From: Nicola Spencer - [REDACTED]
Sent: 24 October 2018 14:19
To: Charlotte Bodin
Subject: FW: R/236/18/HH
Attachments: Plan Rev B 24-10-18..pdf

I can confirm my acceptance of the amended description "Proposed car port boundary wall to front and associated landscaping".

EAST Proposed 1:100

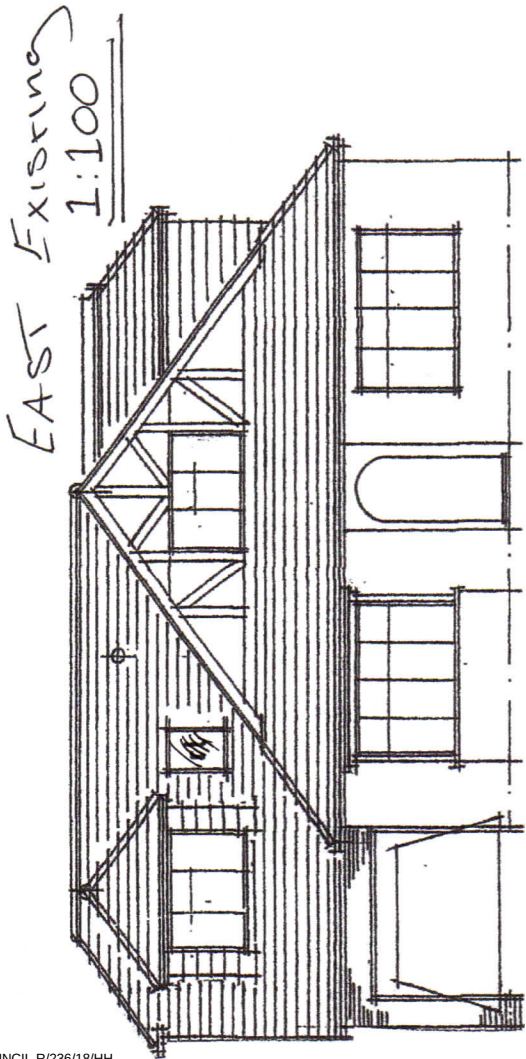
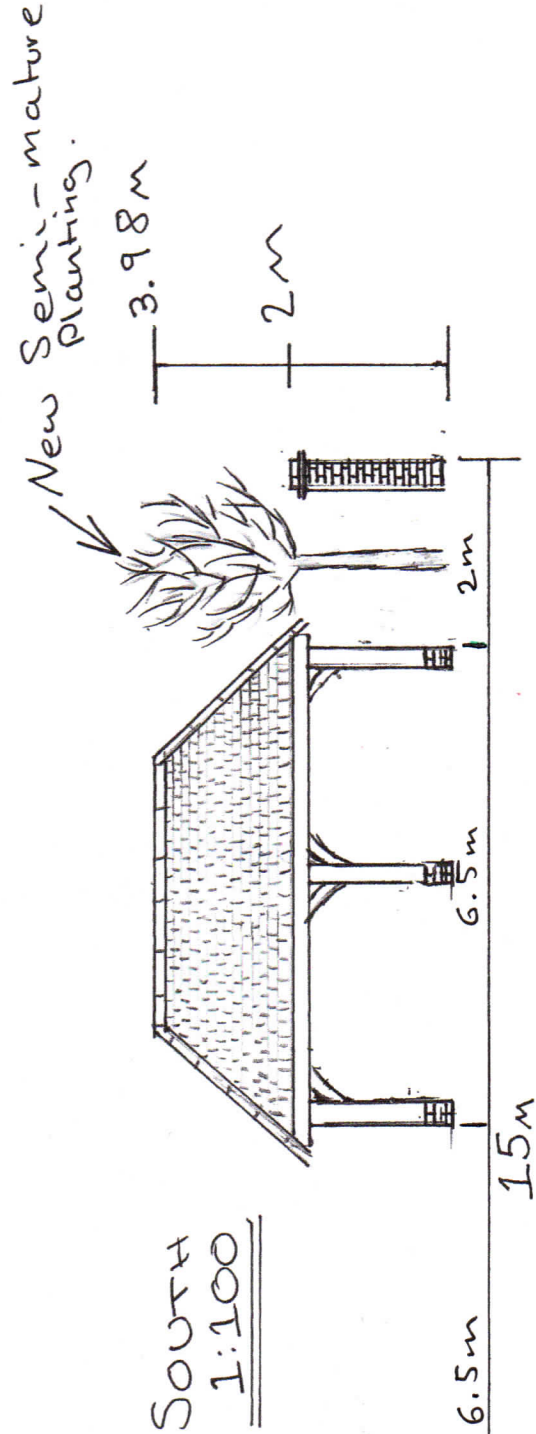
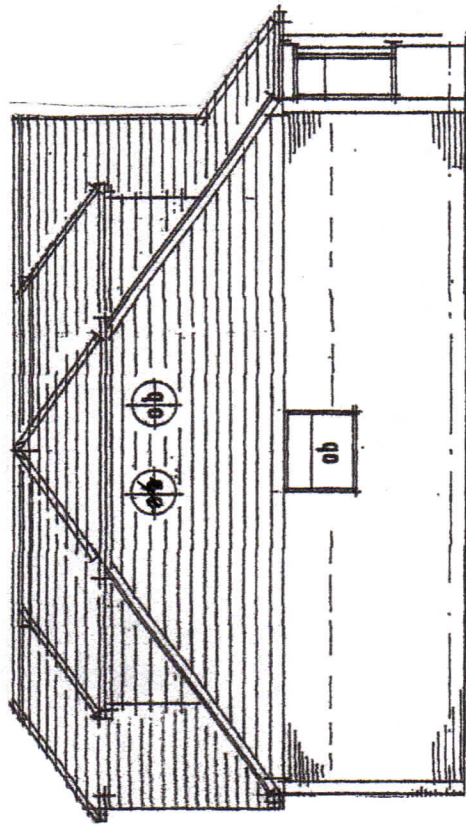
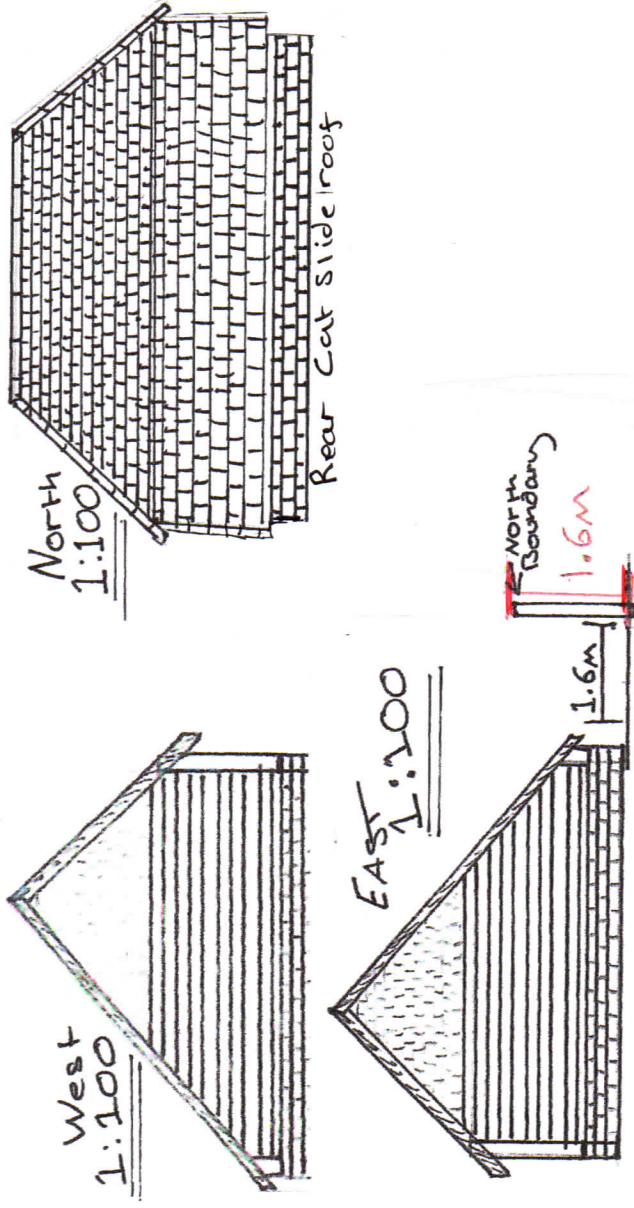
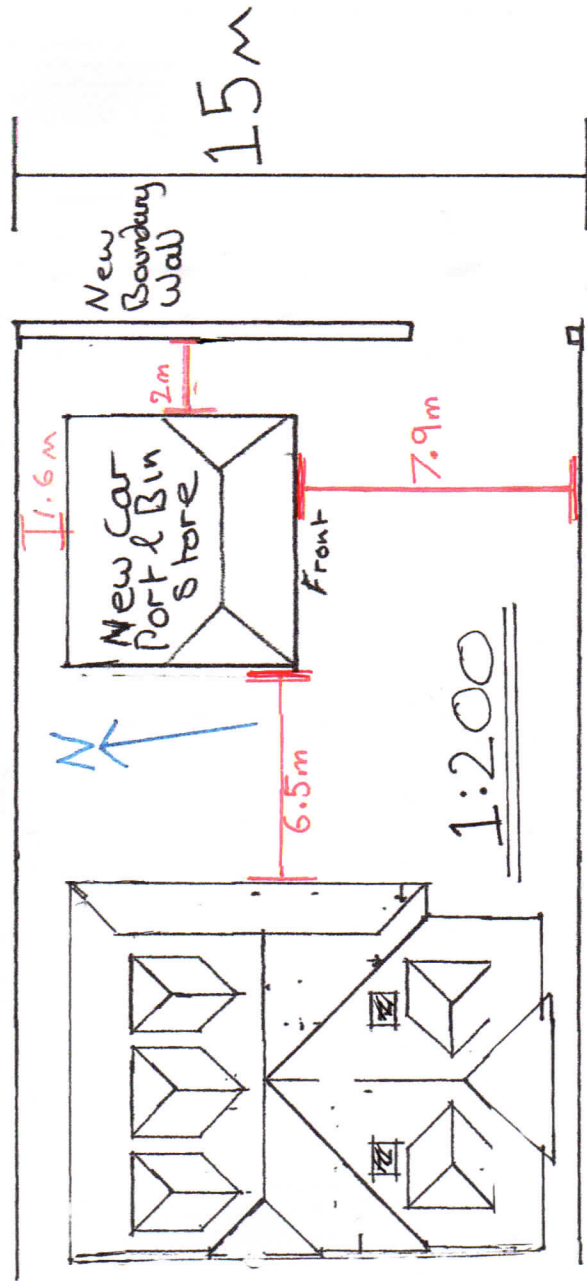
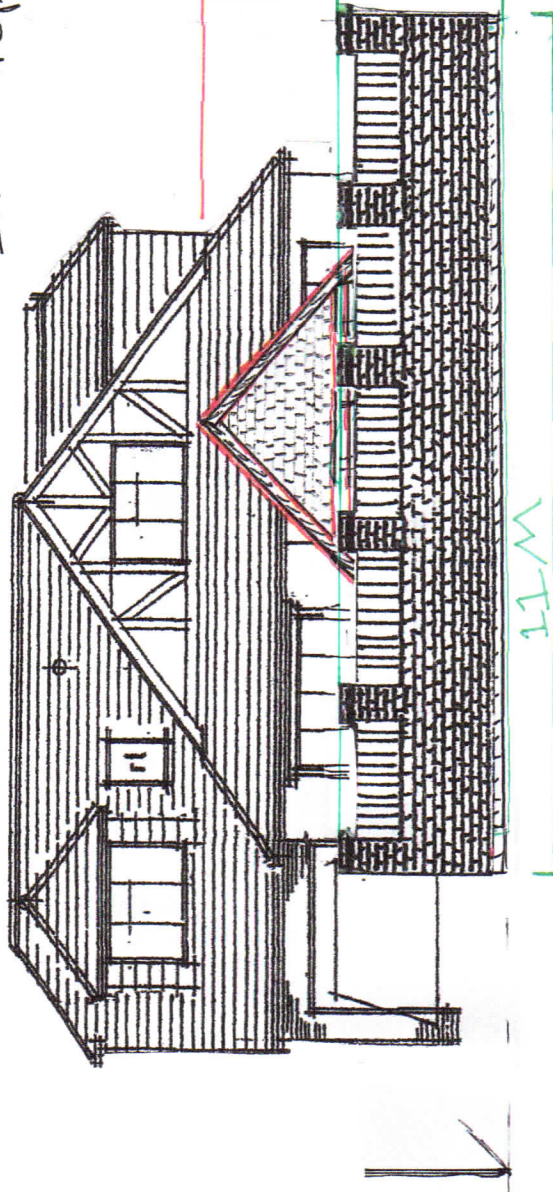
East Proposed, I have amended the 11m dimension of the front wall.
